# Rezoning Transportation Analysis

Petition Number: 2023-139

Date	Description
11-21-23	First Review (ME)

1 SITE PLAN - SIGNAGE LOCATOR MAP
1" = 40'-0"

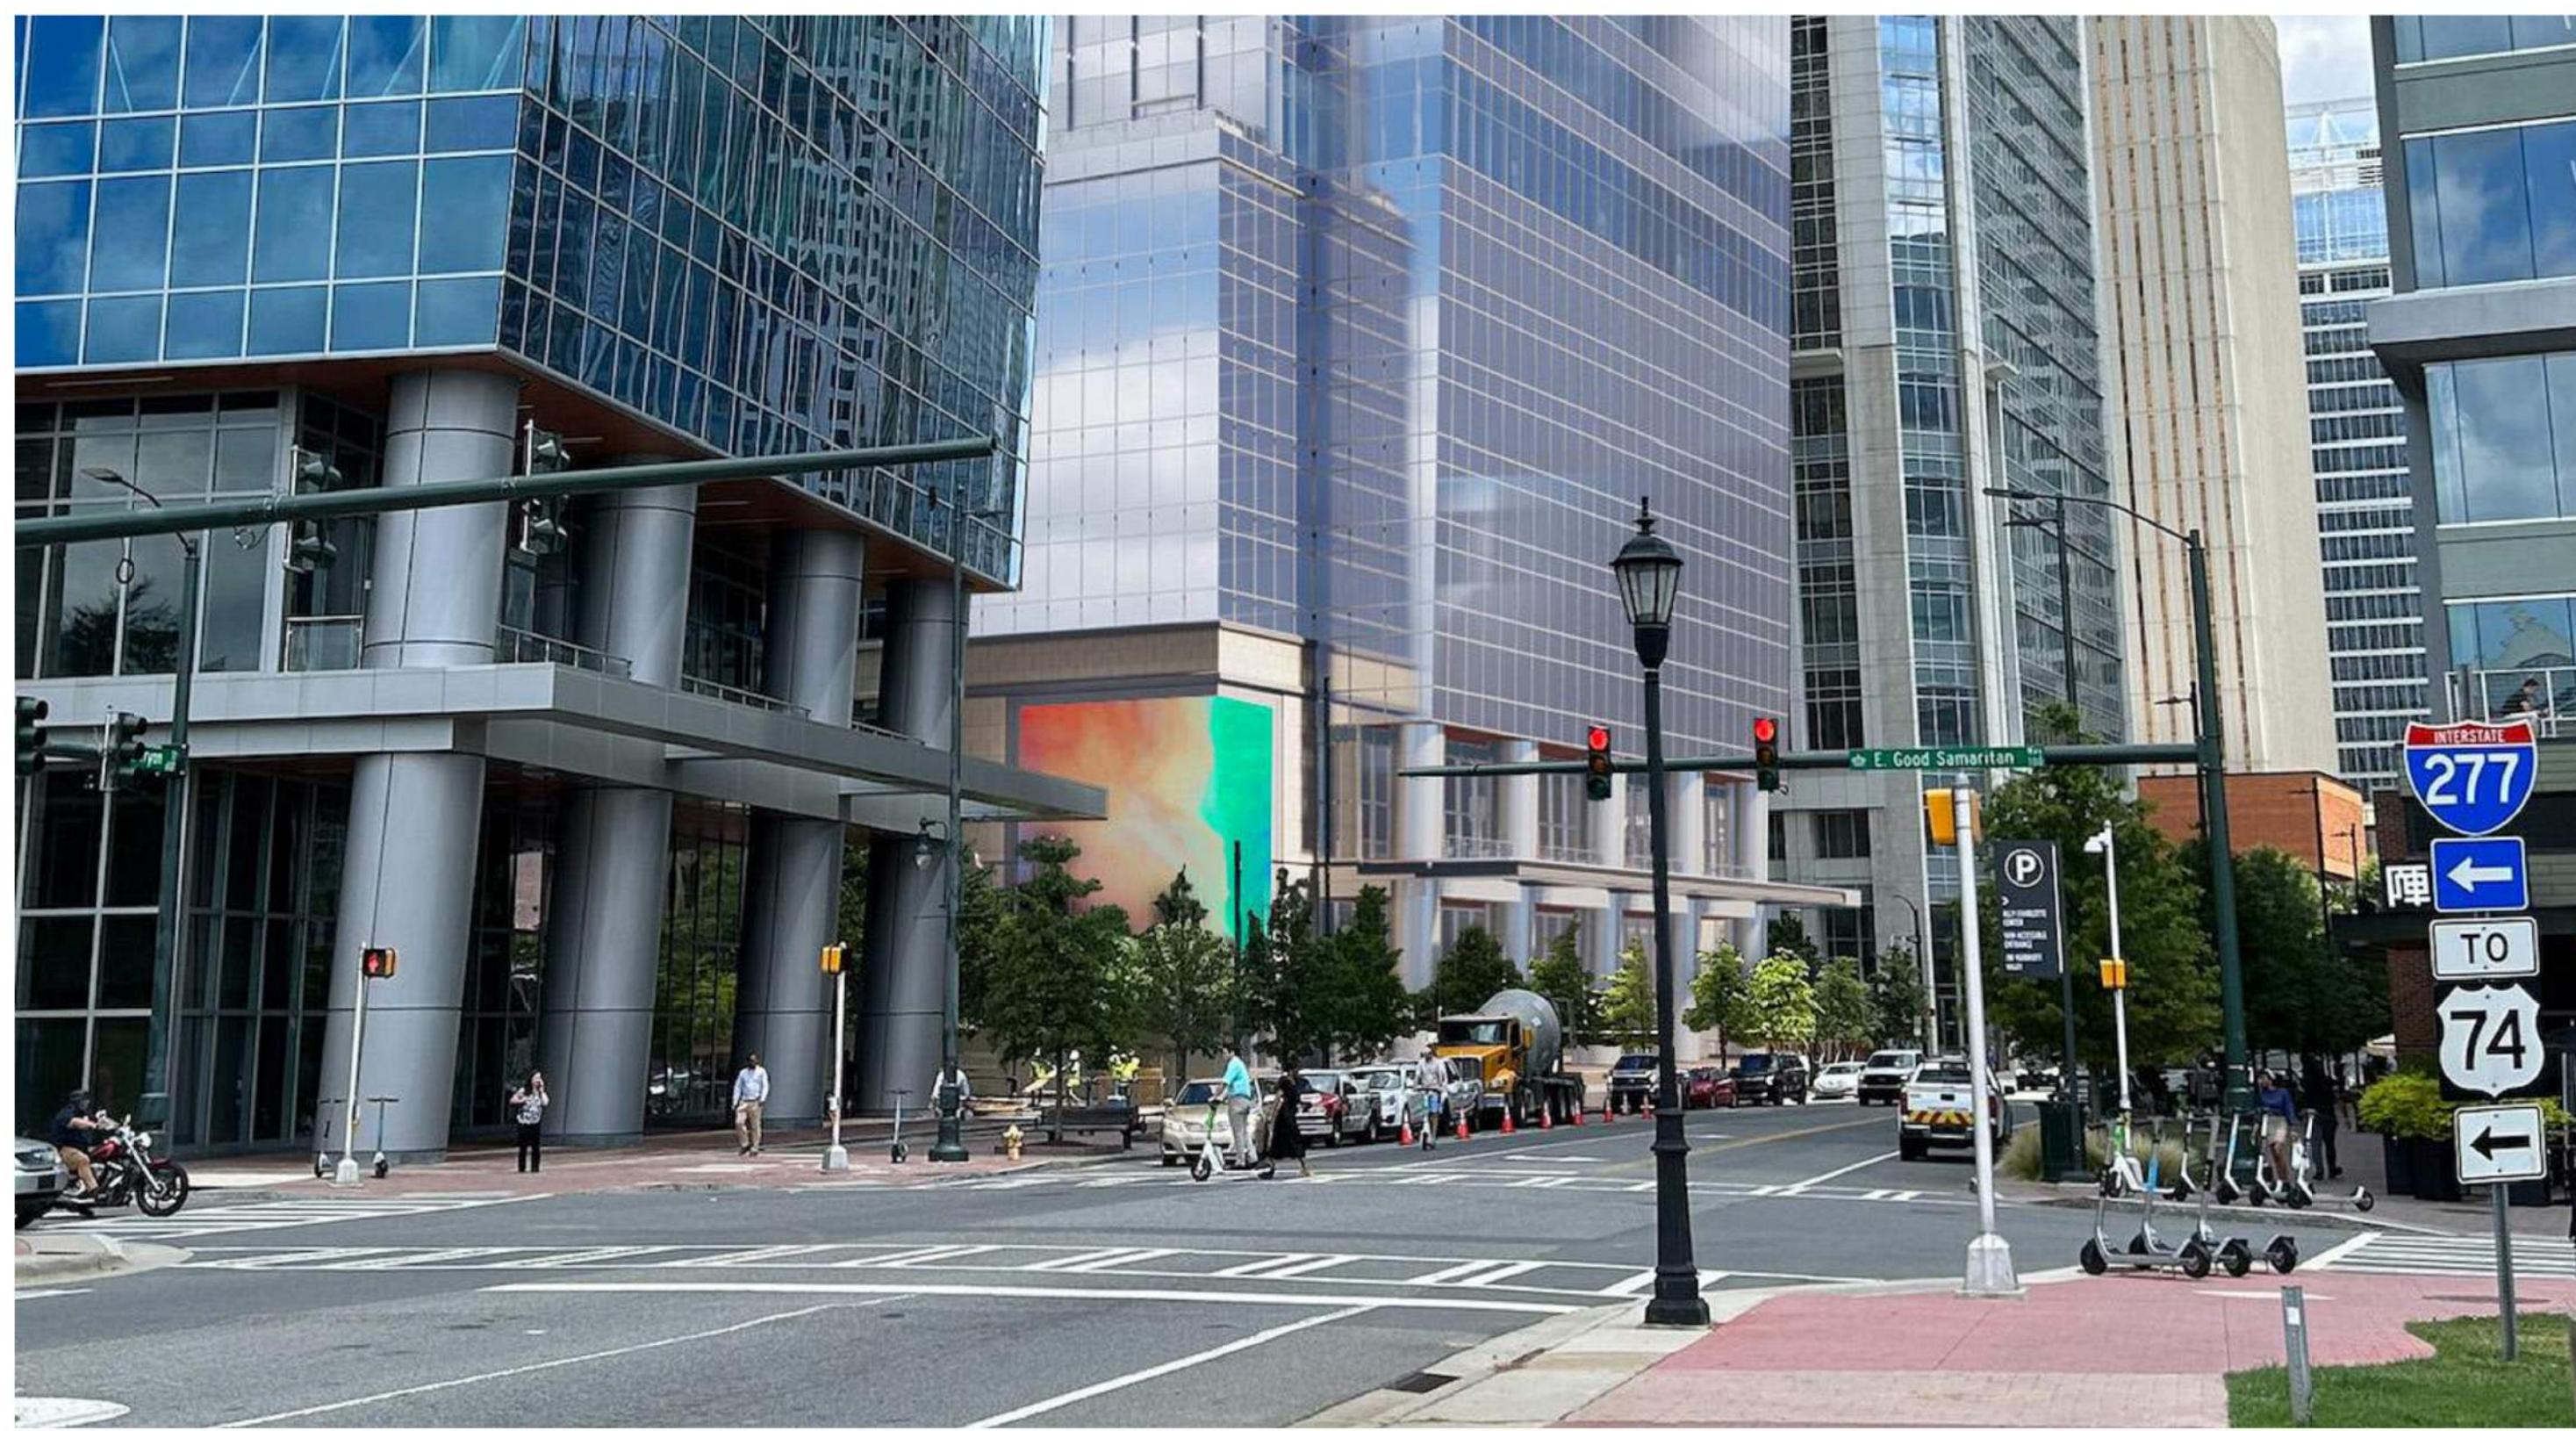
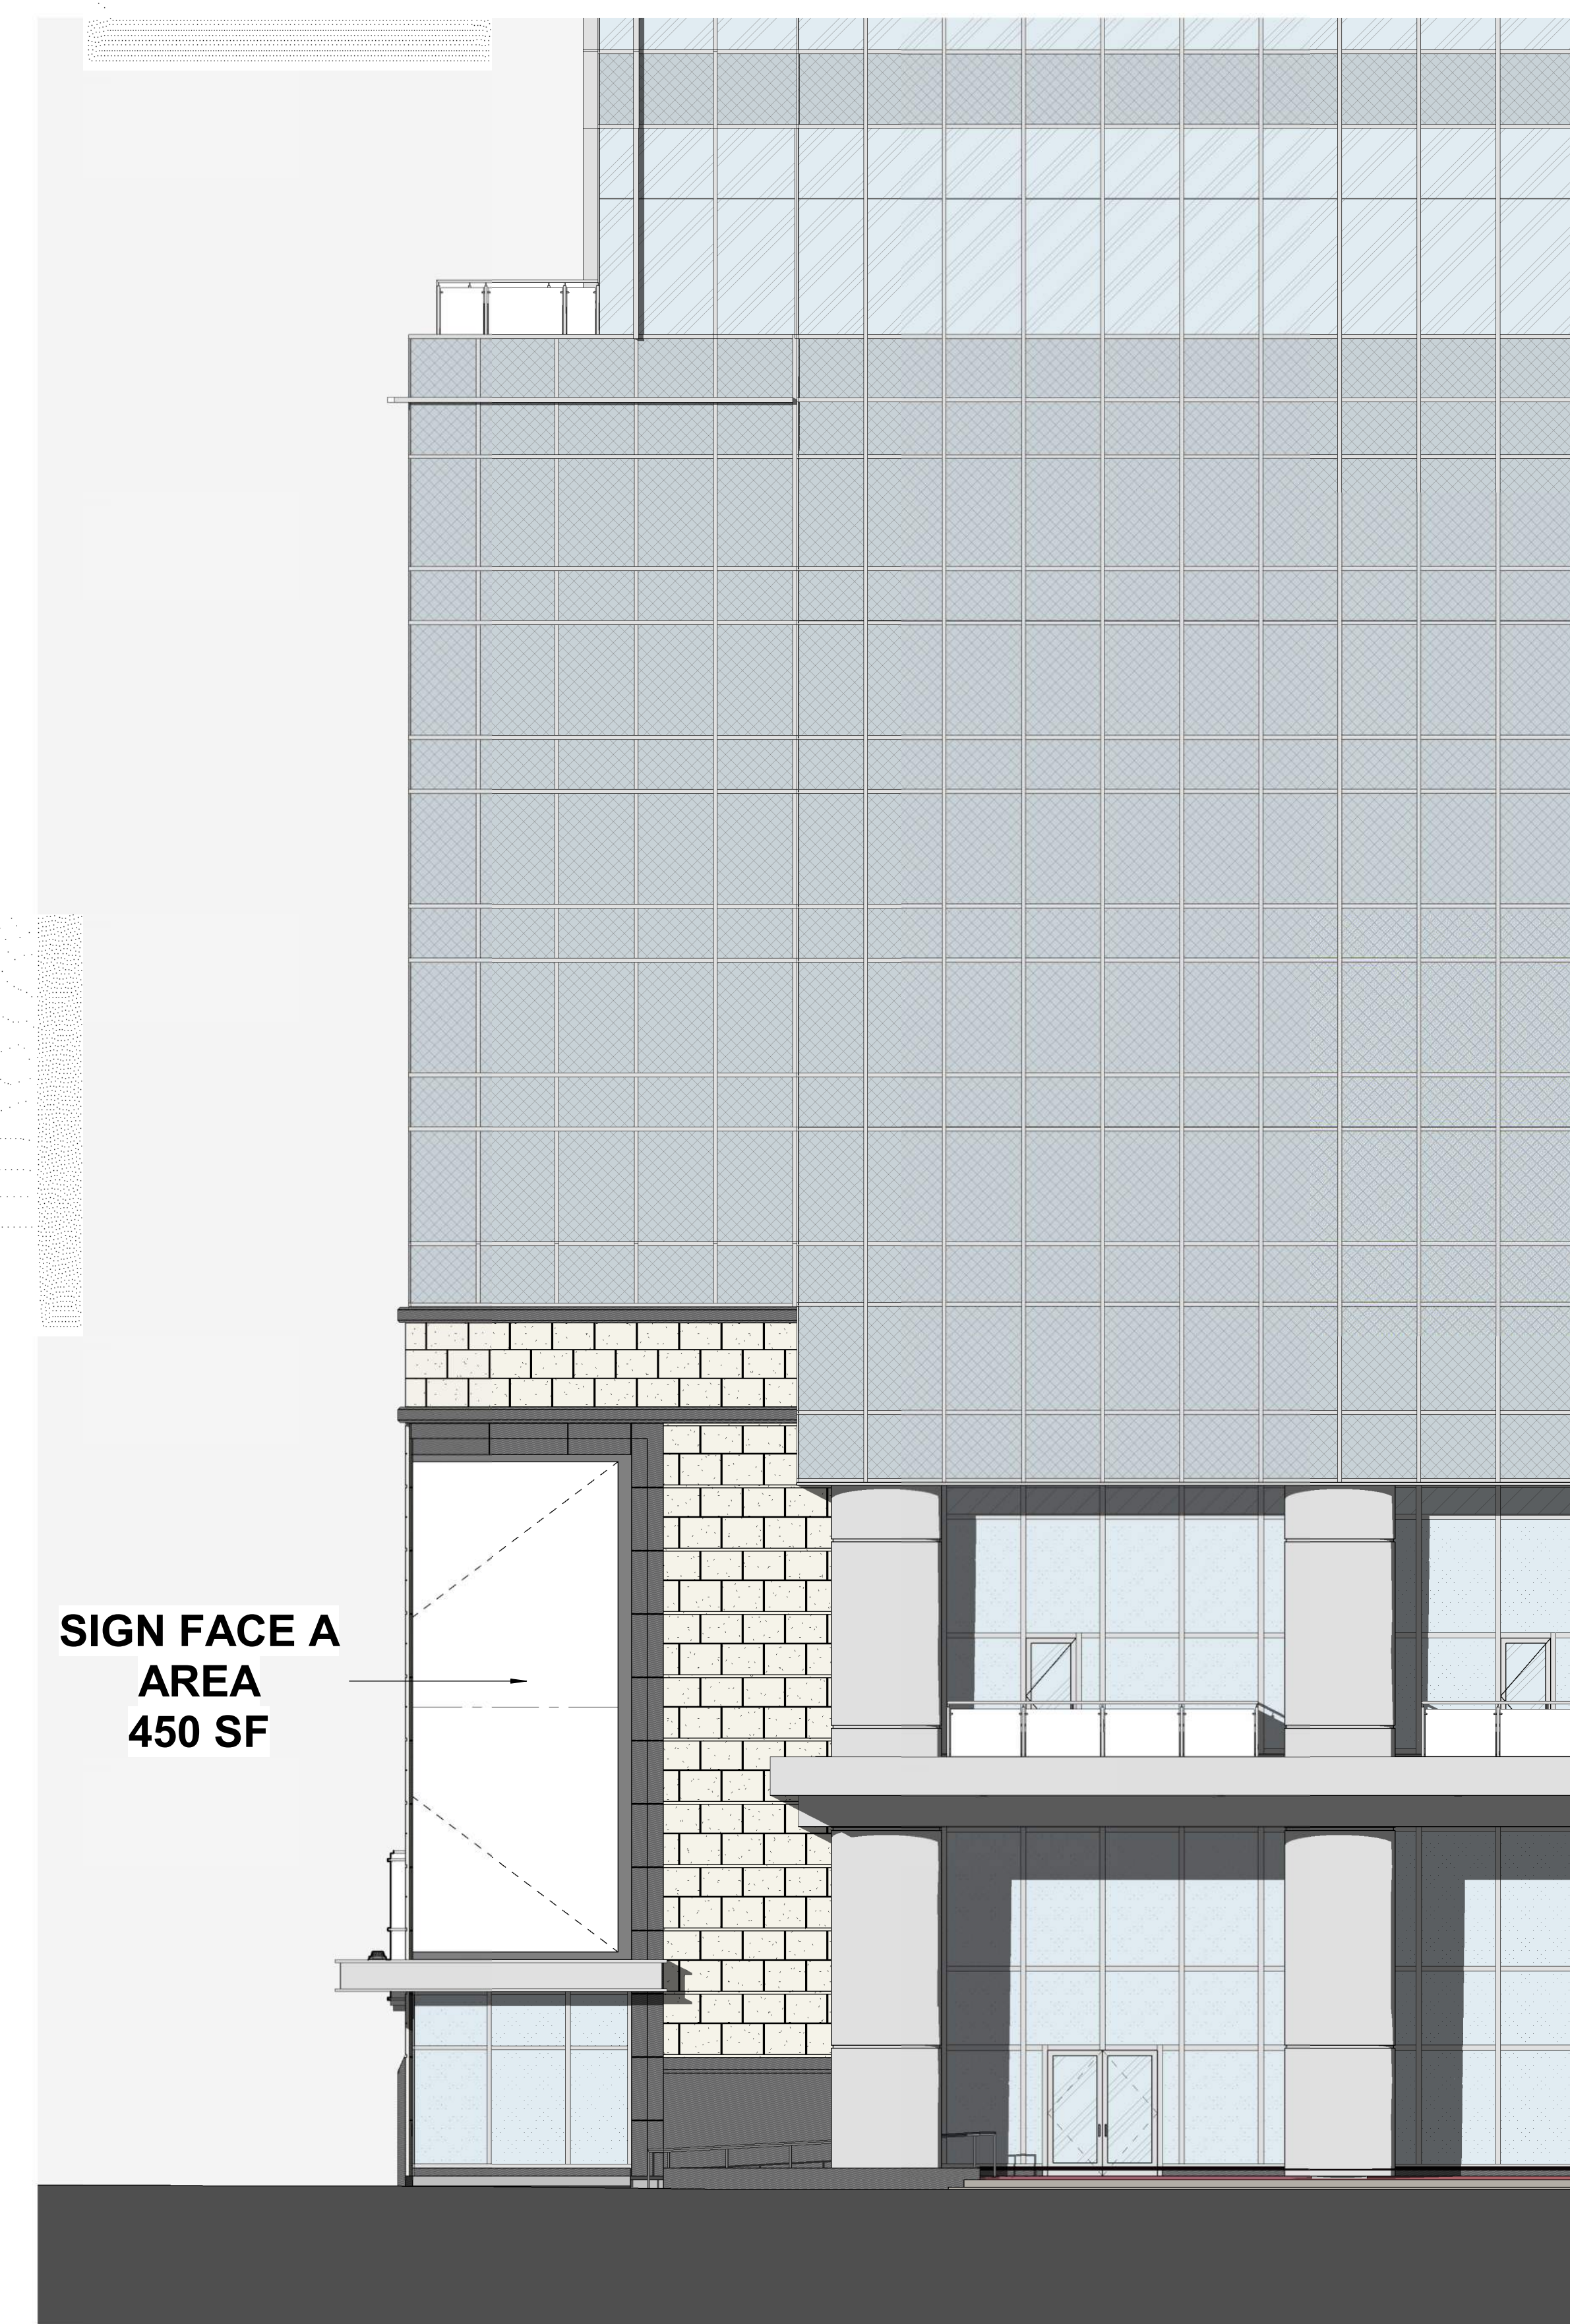
- 2.** Add a conditional note specifying “A Right-of-Way Encroachment Agreement is required for the installation of any non-standard item(s) (signage, irrigation systems, decorative concrete pavement, brick pavers, etc.) within a proposed/existing City-maintained street right-of-way by a private individual, group, business, or homeowner's/business association. An encroachment agreement must be approved by CDOT prior to construction/installation. Contact CDOT for additional information concerning cost, submittal, and liability insurance coverage requirements.”
